## **MEMORANDUM**

SUBJECT: Frederick (BLA/SEG-06-50)

DESCRIPTION: Boundary Line Adjustment in Agricultural 3 Zone

TO: Community Development Services  
FROM: Randy Carbary, Planner II *RC*  
DATE: May 8, 2006  
SUBJECT: Frederick Segregation and BLA

FREDERICK PROPERTY

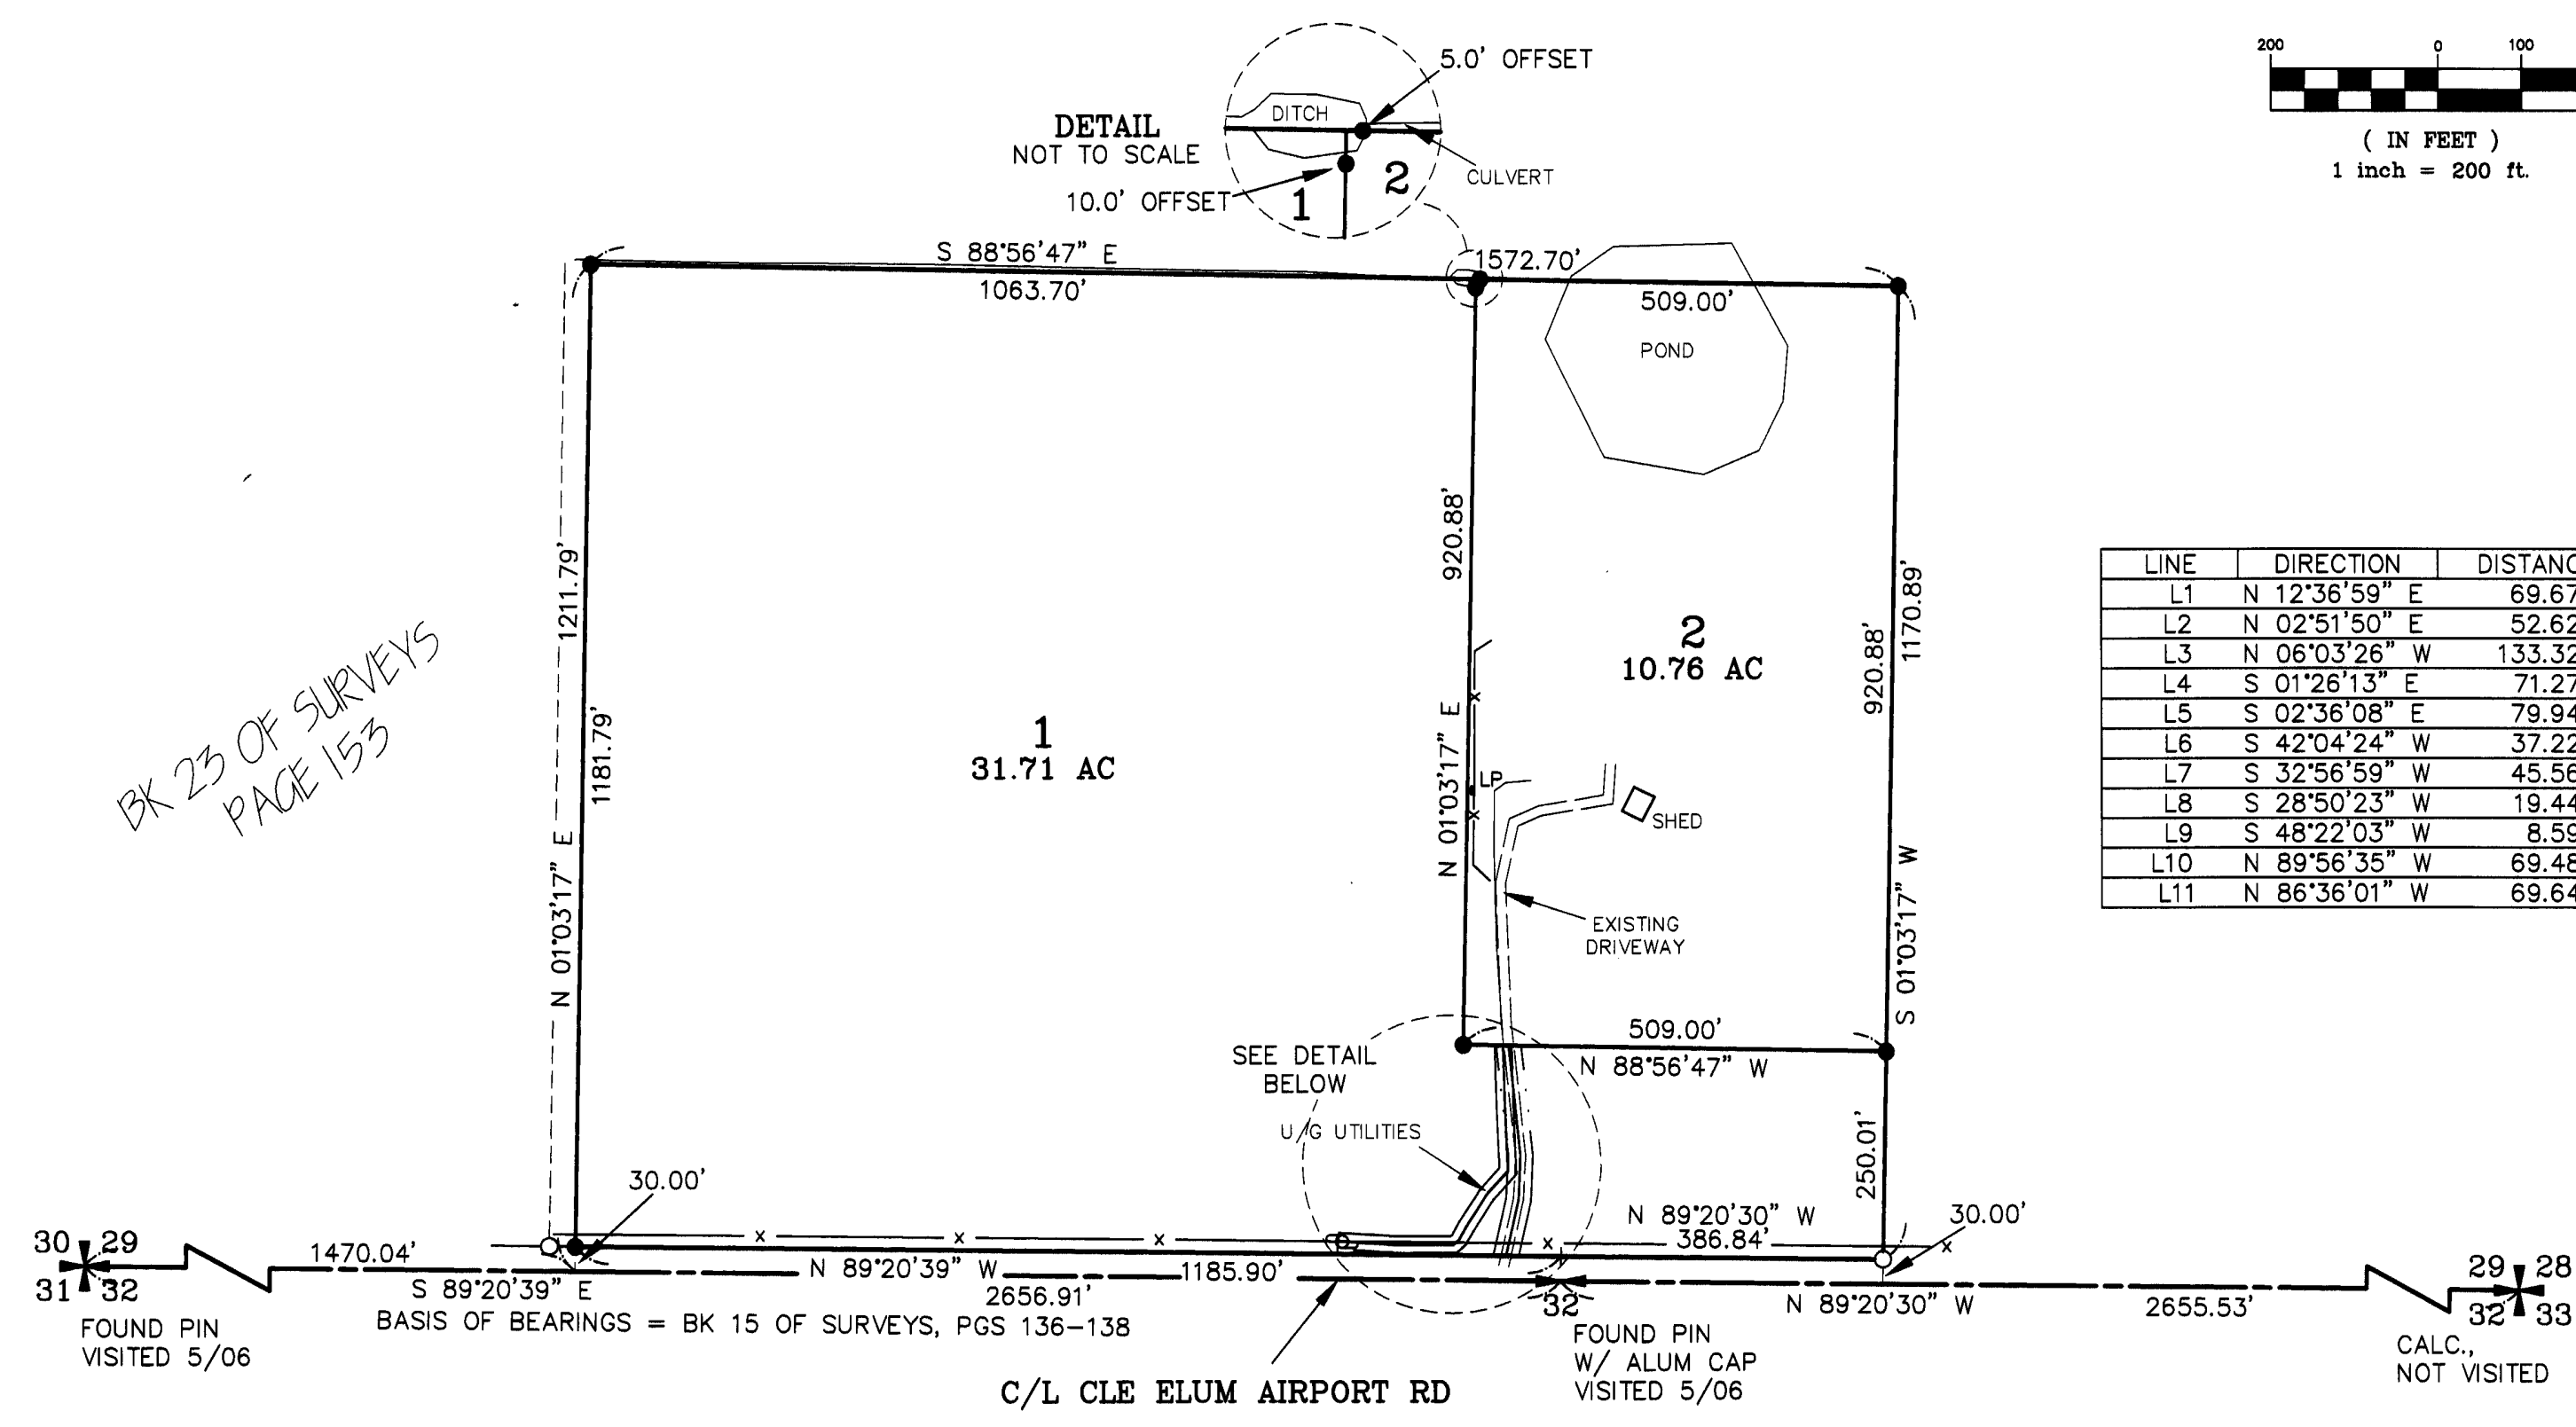
1. A legal description of the Boundary Line Adjustment reflecting the new acreage and lot dimensions must be submitted to our office and reviewed for final approval.
2. Full year's taxes need to be paid for all tax parcel numbers per requirement of the Kittitas County Treasurer's office.
3. Please refer to the attached Kittitas County Public Works Memo for additional information regarding additional requirements.

1. Prior to Final Approval the proposed access with appropriate easement(s) shall be shown and shall conform to applicable Kittitas County Road Standards.
